Deadline 6 Submission on Behalf of the Neighbours and Users of Queen Elizabeth Park

Interested Party reference no: **20022545**

1.2.3. QEP Site Specific Plan

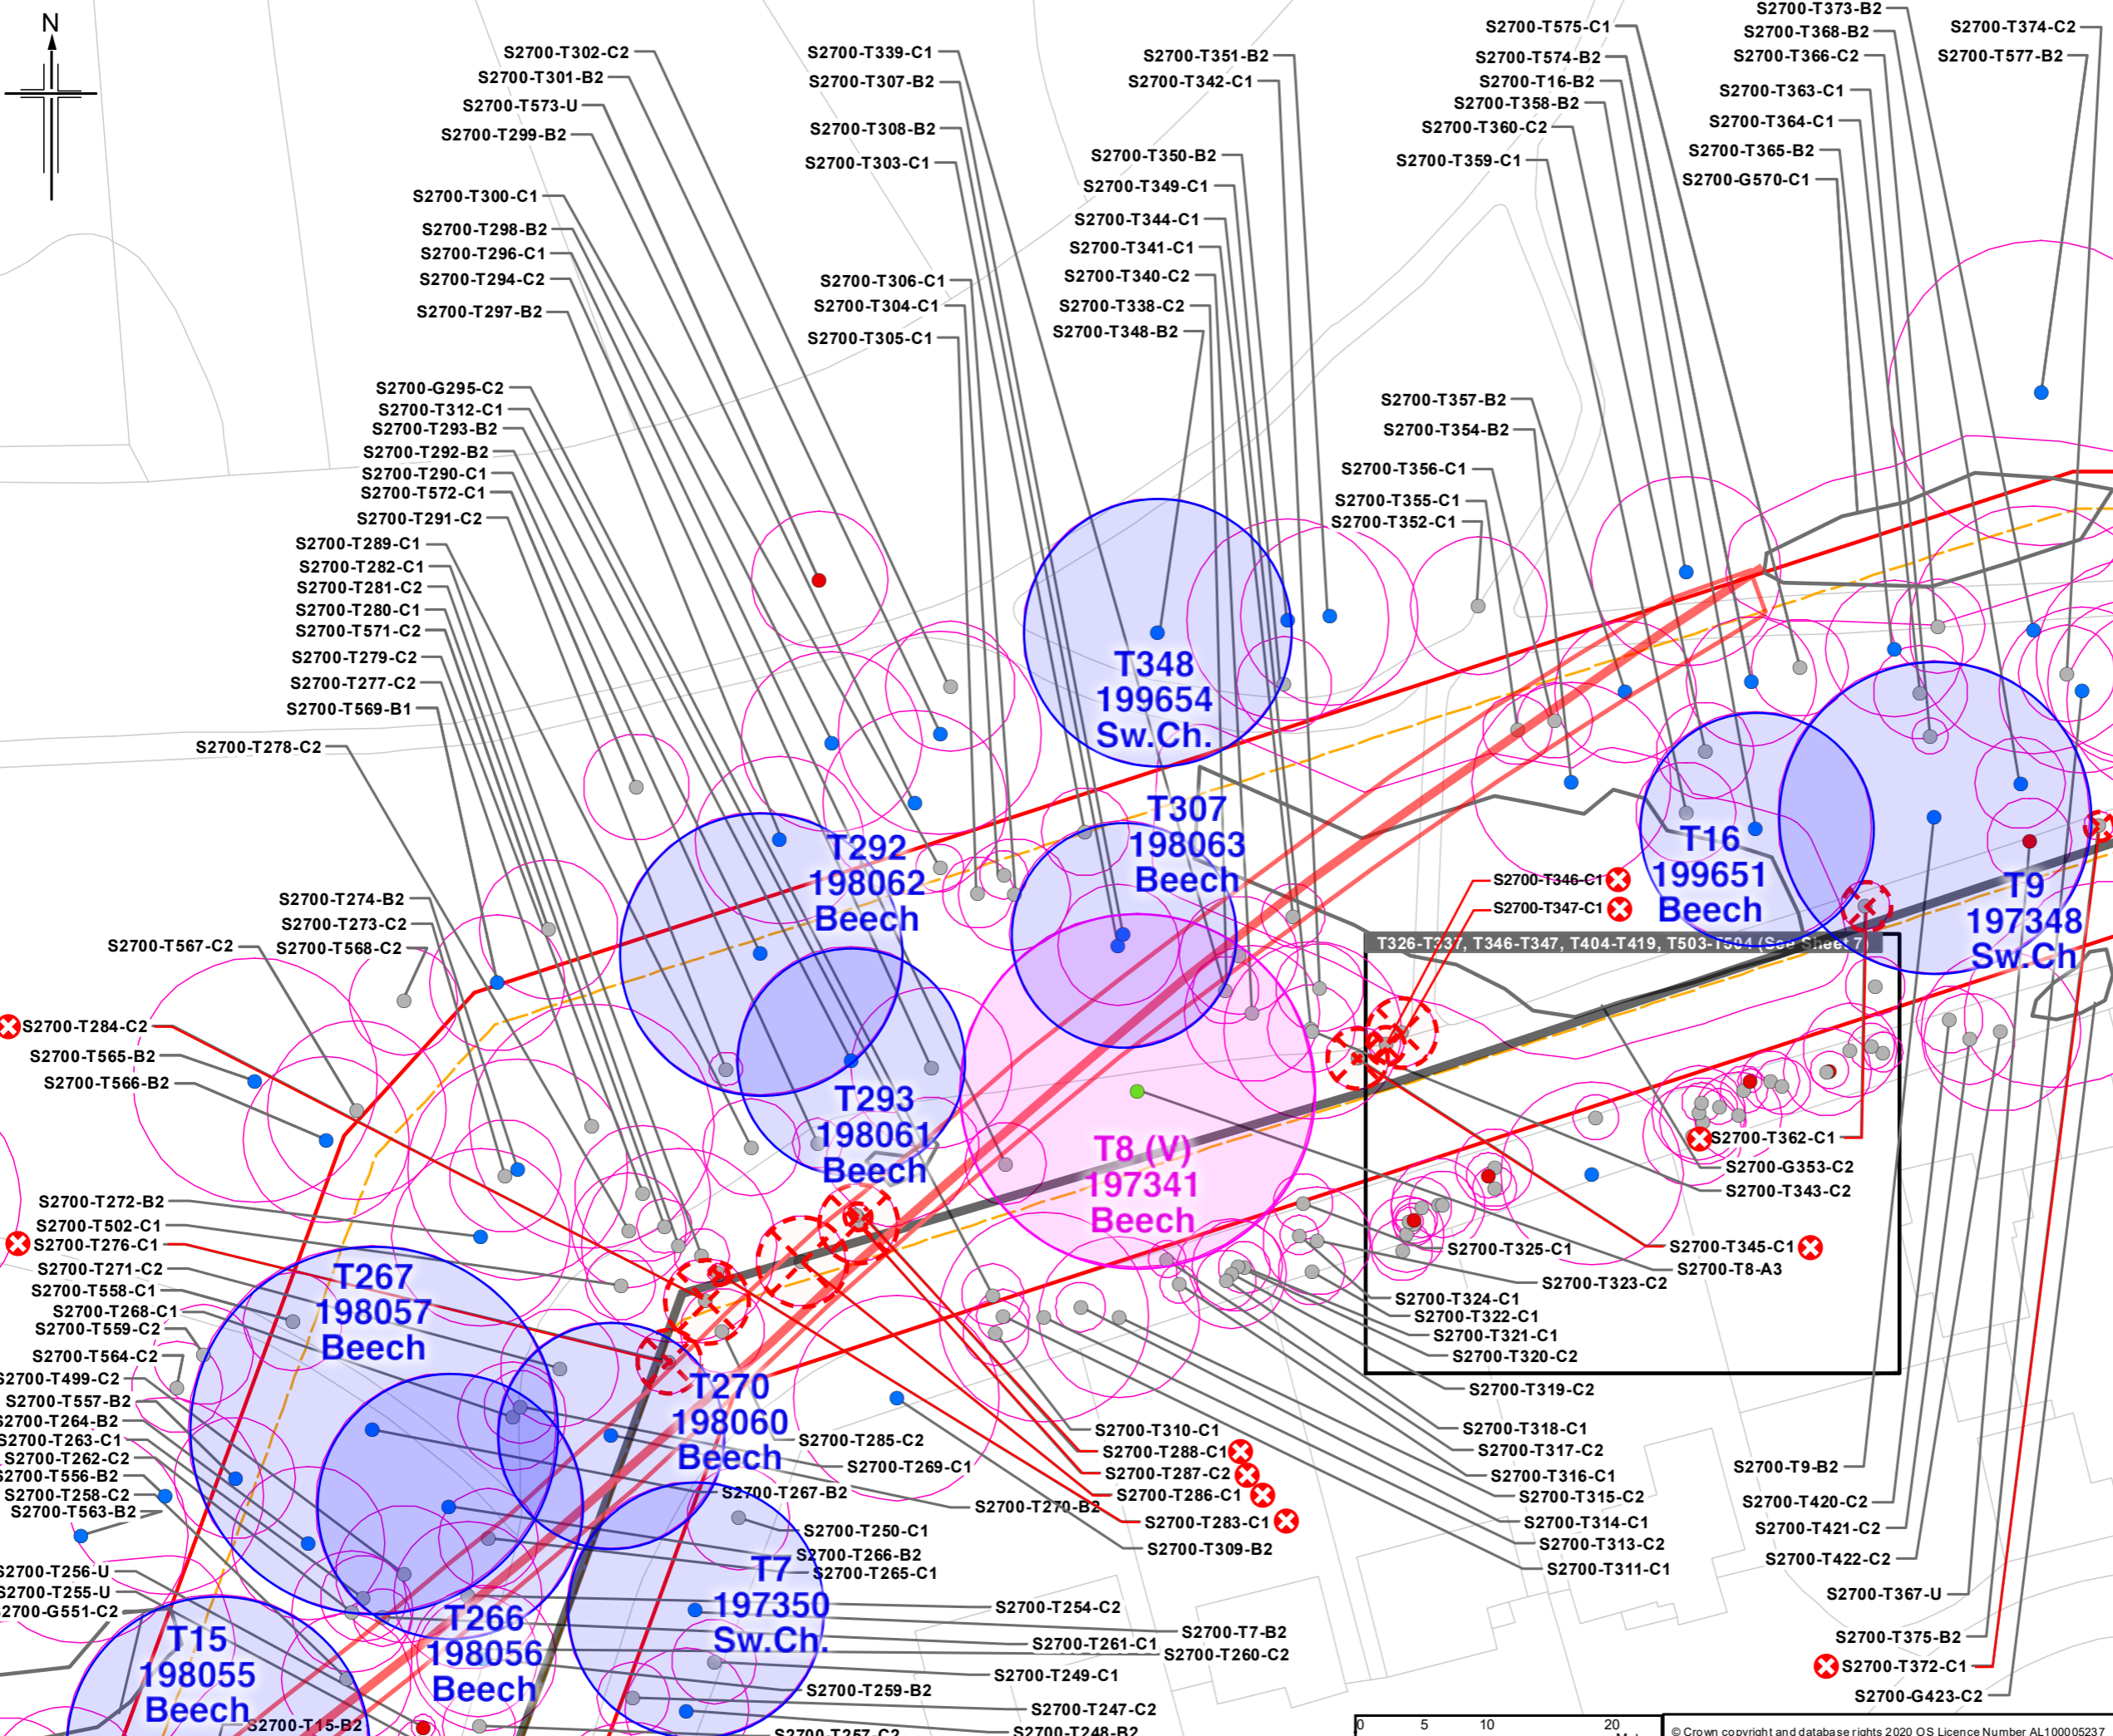
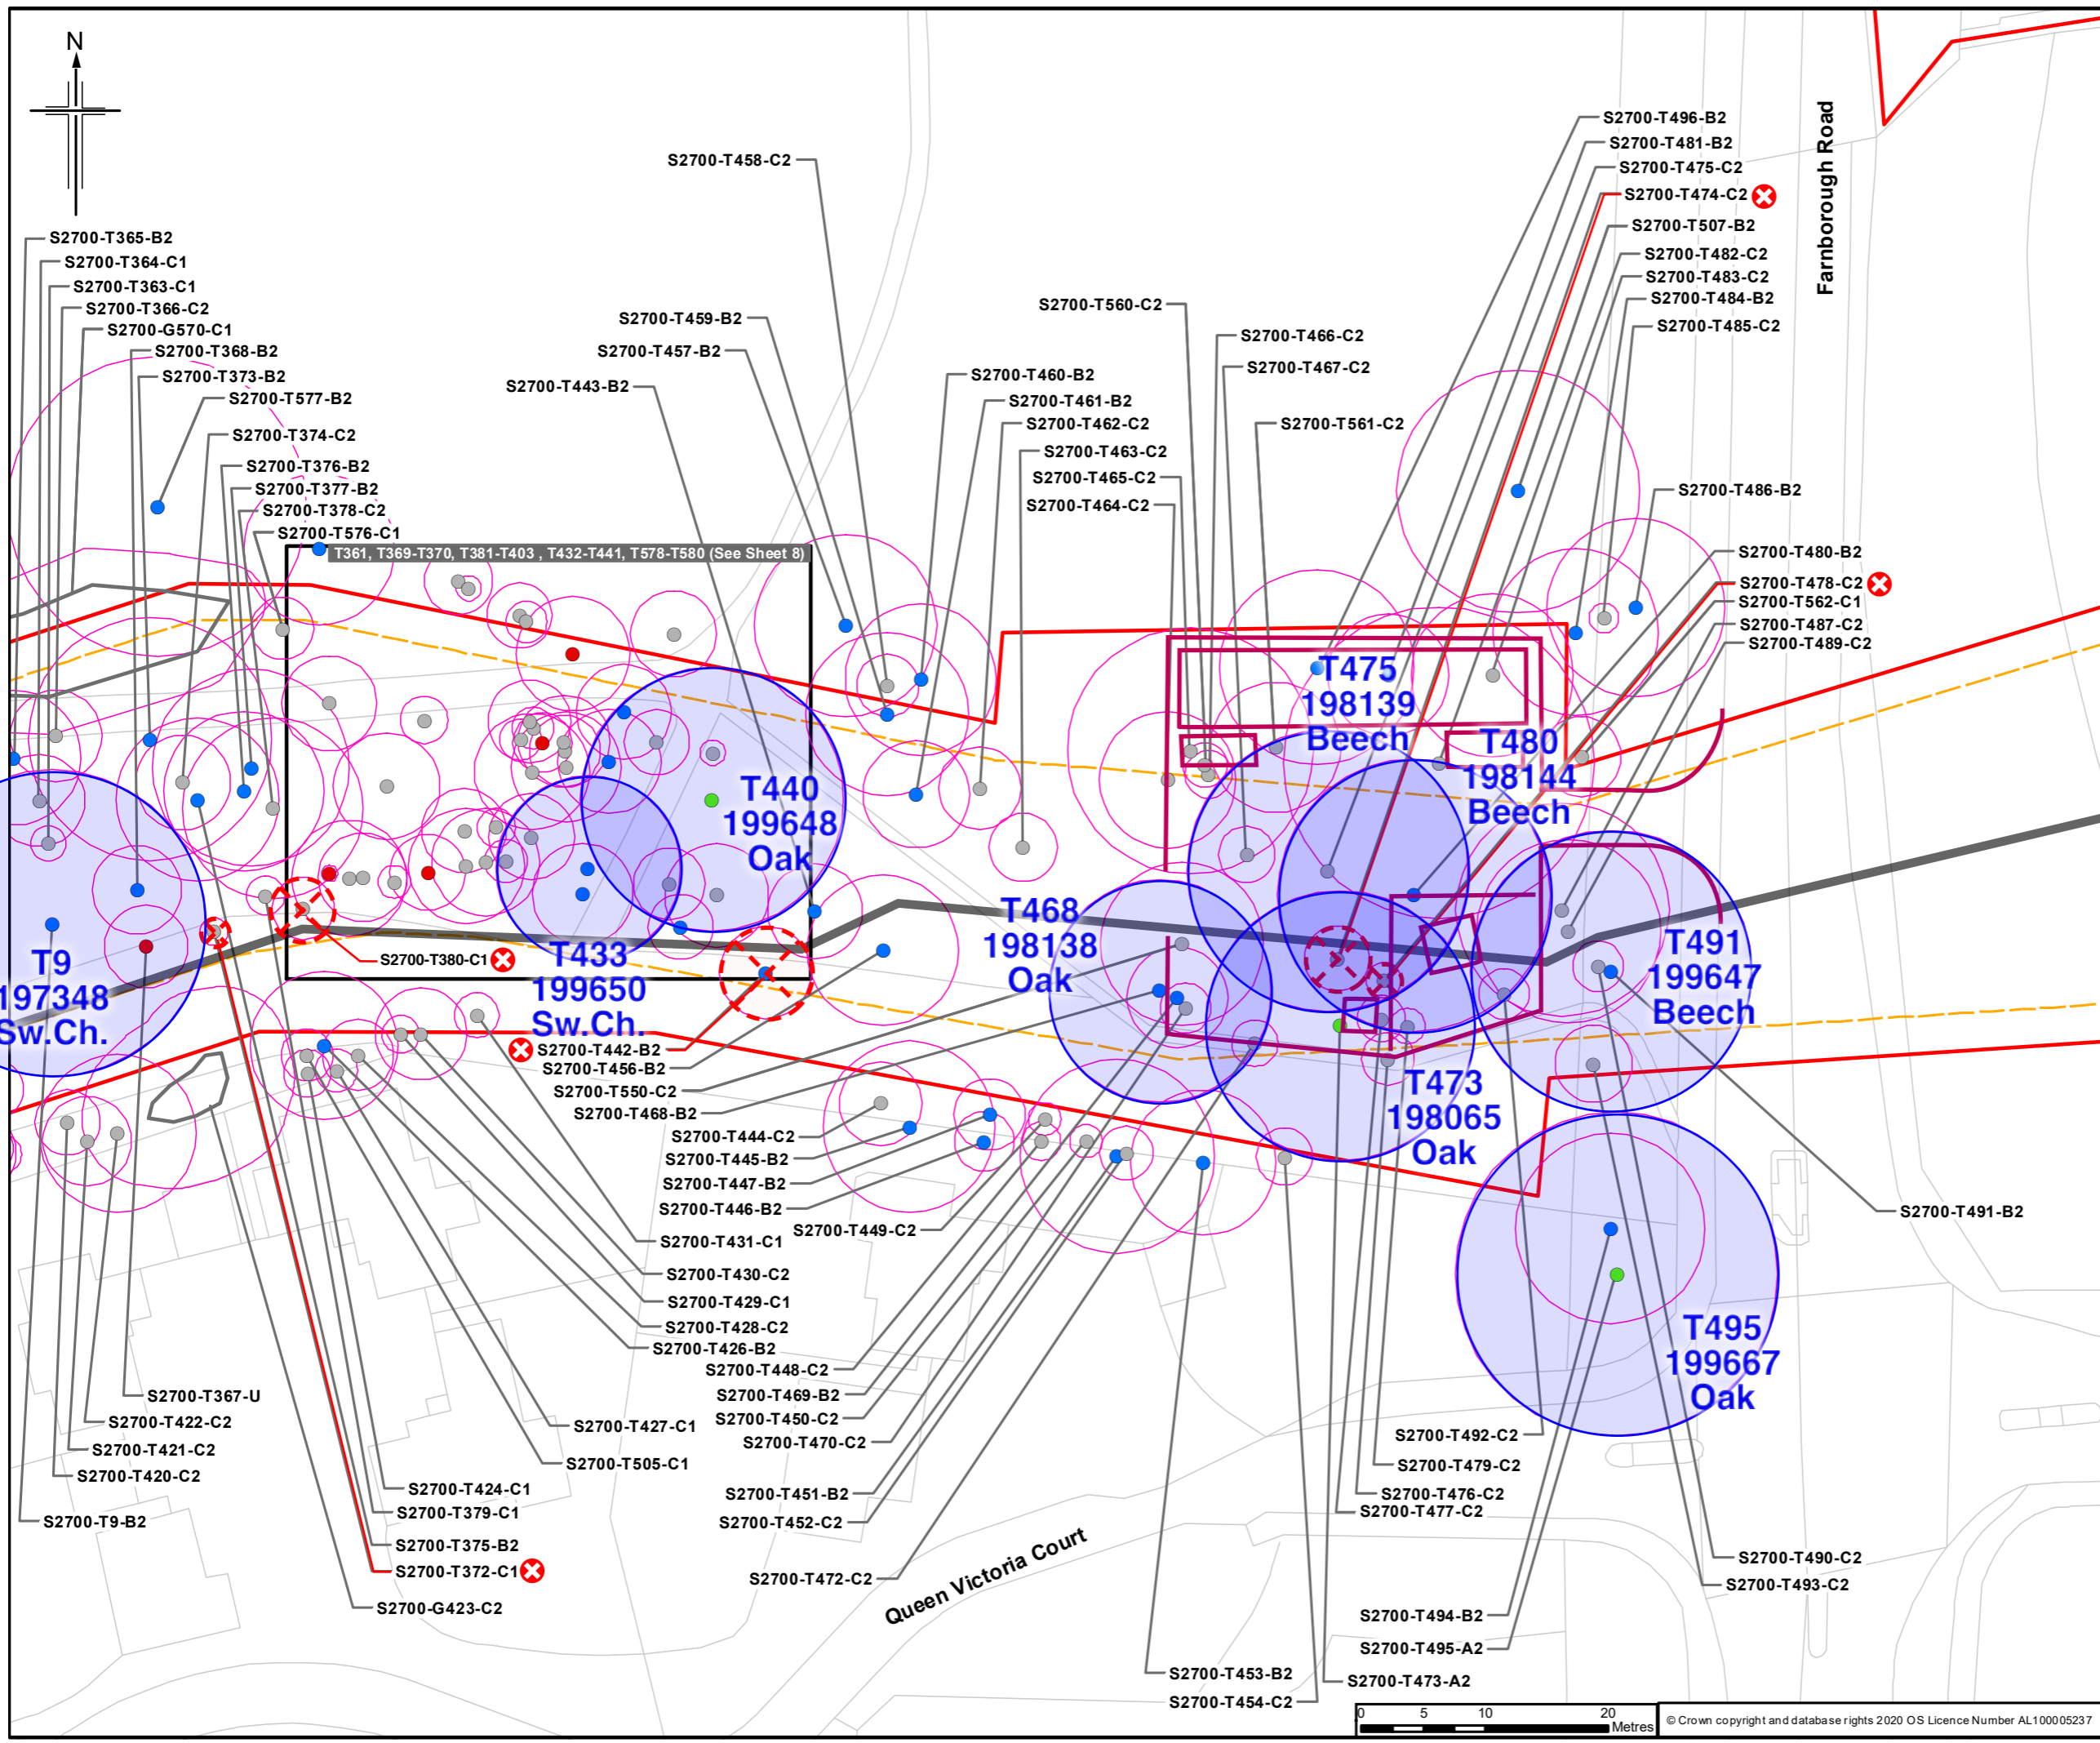
The 30 (approx) trees to be removed were not individually identified by Esso.

We stated our concern that the trench will be very close to trees which Esso say they can retain. We are worried that some of these trees - including Notable and Veteran Trees - will also be lost during installation as a result.

We stated that the route of the pipeline makes no concessions to the position of trees or their root protection areas.

We clarified that 197 metres (37%) of the trench through QEP is within the RPAs of Notable and Veteran Trees and that this would indicate that the proposal to trench through the park is not possible.

We clarified that 100% of the auger bore area is covered by RPAs, belonging to 29 trees, 20 of which are within the compound and 5 of which are Notable.

The ground levels within the area vary greatly so some levelling would be needed to allow access and operation of the area.

This indicates that it is not possible to operate an auger bore pit and compound in that location. Furthermore, Esso's claims that they could retain all the trees in the area did not seem possible.

Esso have not provided a list of trees to be removed, merely a vague statement in paragraph 3.3.4 of the QEP SSP³ that ‘approximately 30 non-mature trees will need to be removed’. These trees are not identified in the survey. In fact the only indication of which trees will be removed is on a small scale plan entitled ‘Queen Elizabeth Park: Construction Stage’, included in the QEP SSP.
